Development Facilitation Team (DFT) – Review Comments

DRB Project No: PR-2020-004138 Date: 04/26/2023 Agenda Item: #6 Zone Atlas Page: R-15

Legal Description: [A-1-A-5-C, MESA DEL SOL INNOVATION PARK]

Application For: SD-2023-00081-PRELIMINARY PLAT (DHO)

Sheet 3 of 5

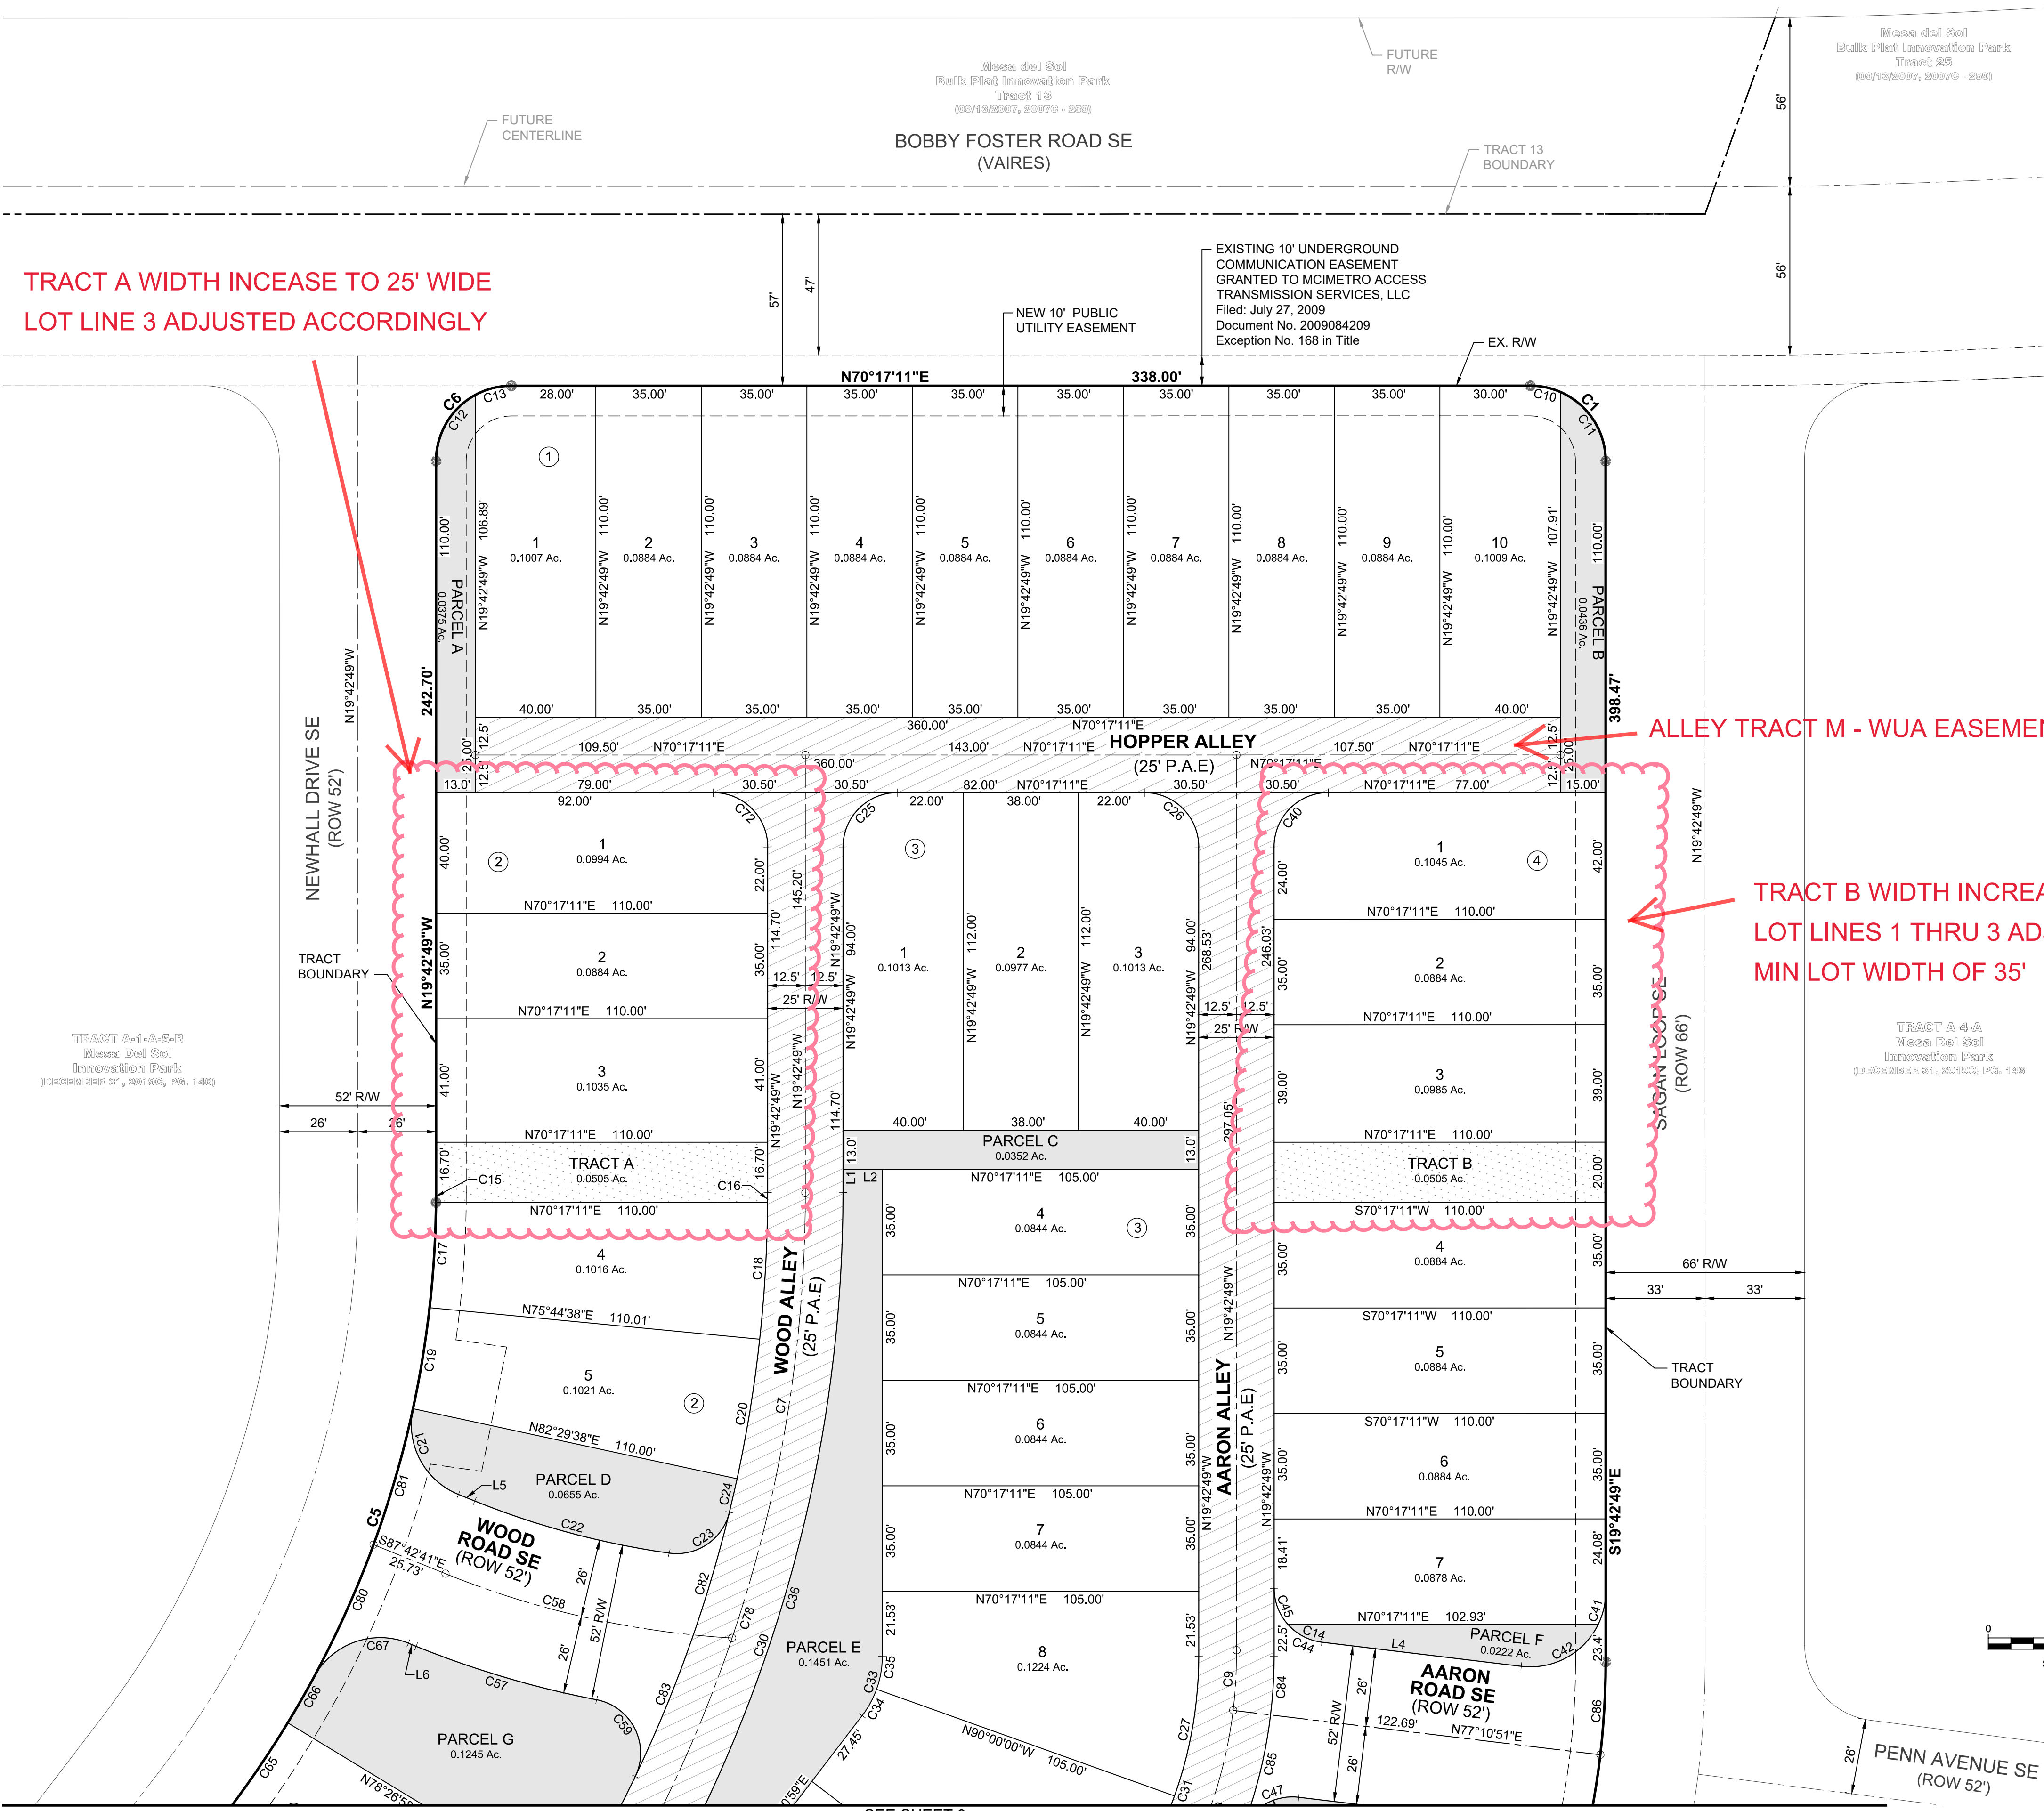
3. The plat states R/W (right-of-way?). Please clarify if this is a public alley or a private.
4. Please include a utility plan that matches the proposed infrastructure list.

6. Please explain the "Parcels" on the plat. Are these available for utility corridors? (previous comment)
 - a. To provide the necessary looped infrastructure noted on the Availability Statement, Parcel K, D, and A will need a corridor across it to access Sagan and Newhall.

7. (Previous Comment still applicable) The proposed alleyways are insufficient width to provide water and sewer service to each of the lots without connections to the offsite roadways. Such service connections are not prohibited by ABCWUA but may be objected to by City DRC. If internal mains are required for service

connections, a wider right-of-way will be required, of at least 25 feet, but generally more such that the proposed curbs and sidewalks are outside of the WUA corridor.
